BL-25-00004 Brown Rd Estates LLC

Kittitas County Public Health Department has comments regarding the boundary line application. The comments are as follows:

SOLAR DOLAR, LLC SITE PLAN

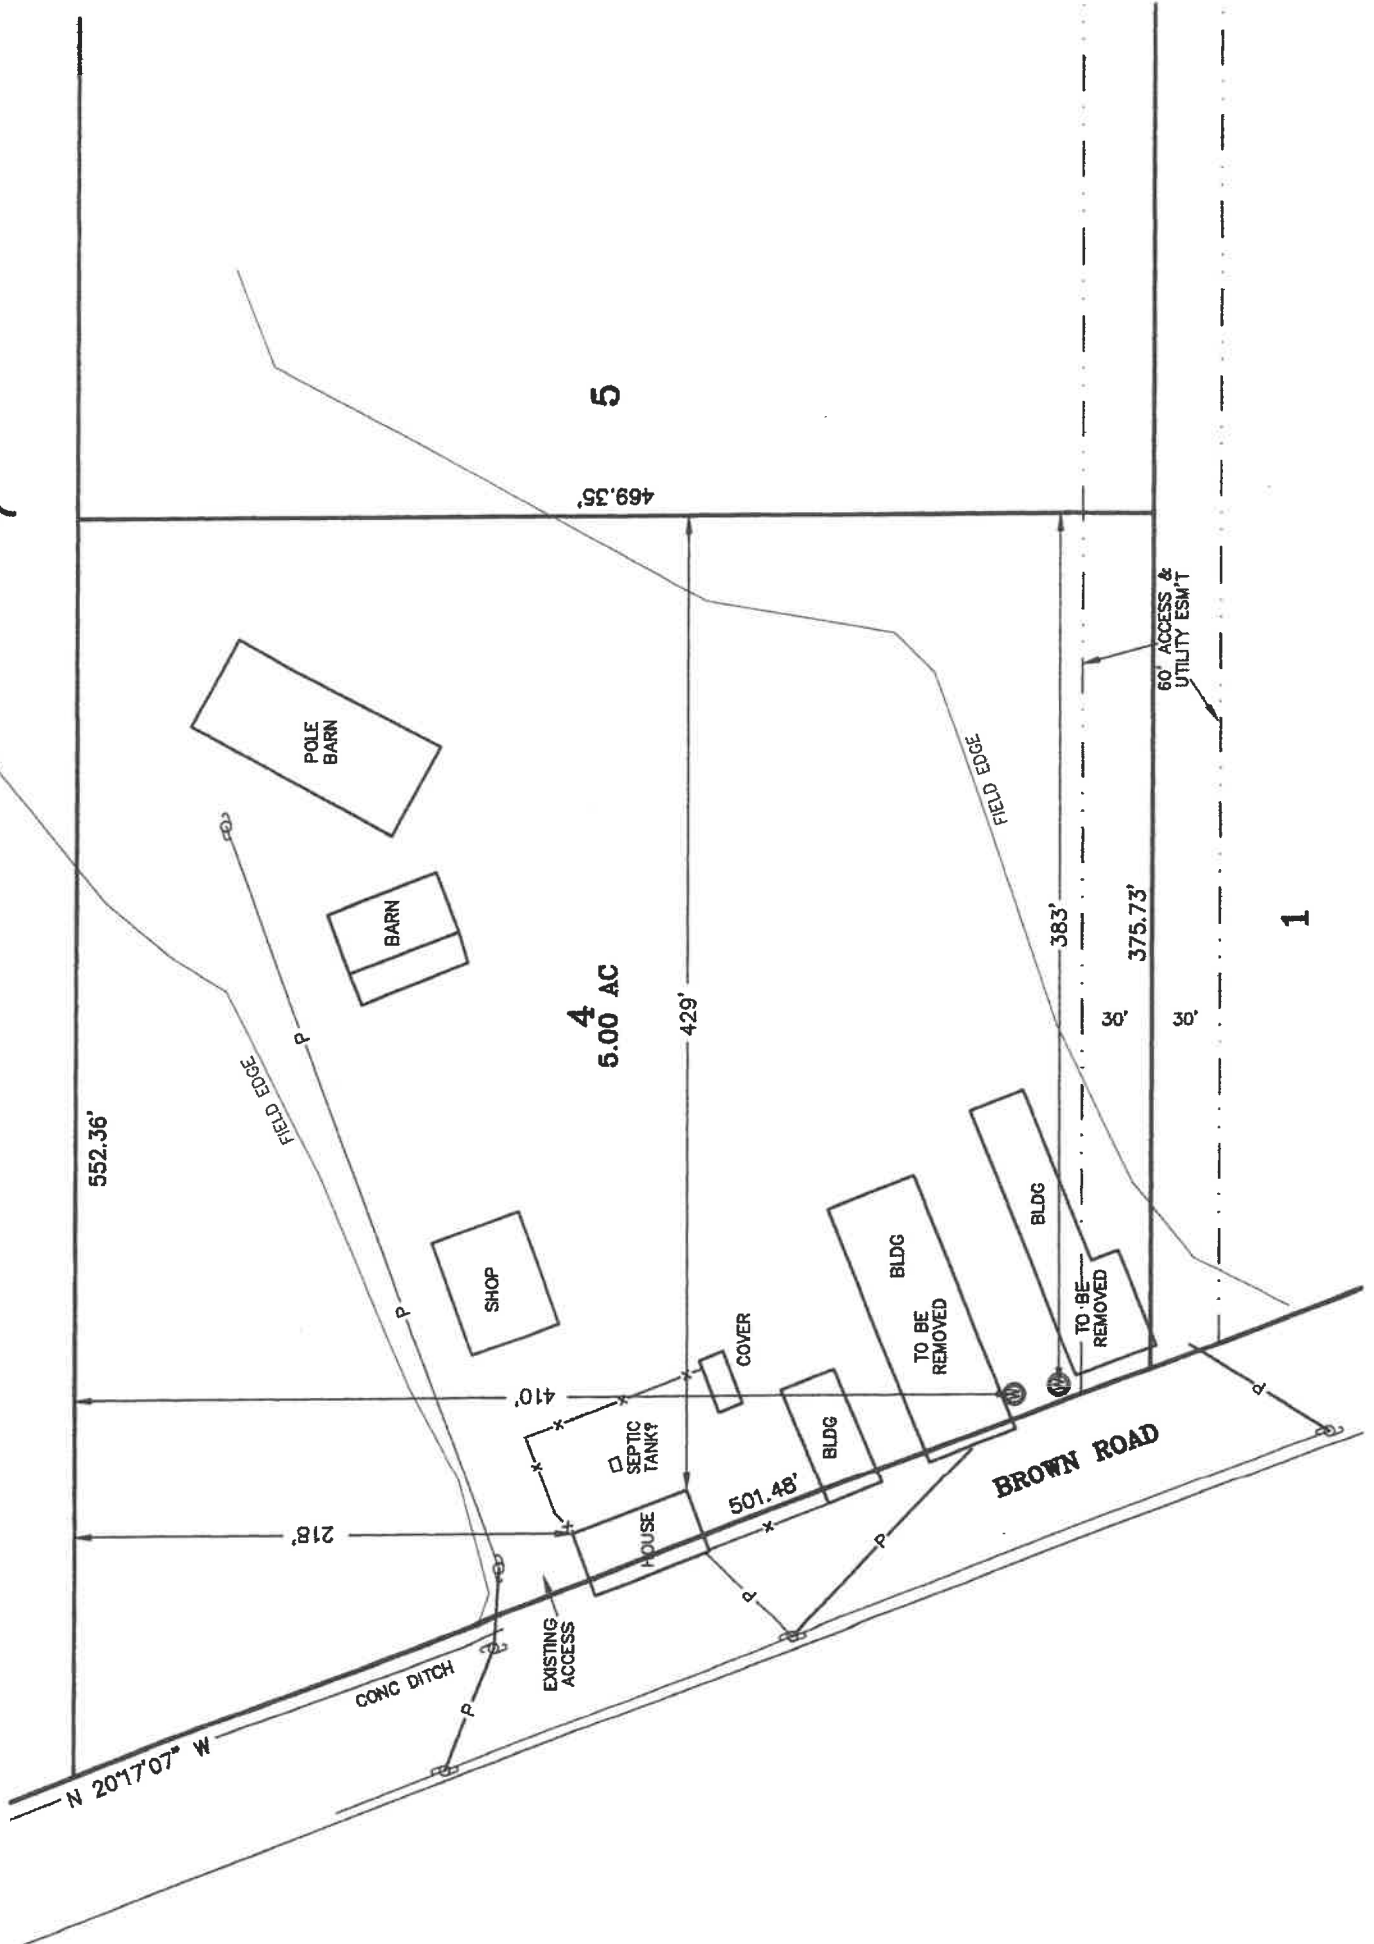
1. For parcels 1,2,3,5, 6, and 7 a soil log will need to be performed to determine the soil type. Soil logs are not the same as site evaluations for septic systems.
2. Submit an adequate water supply determination.
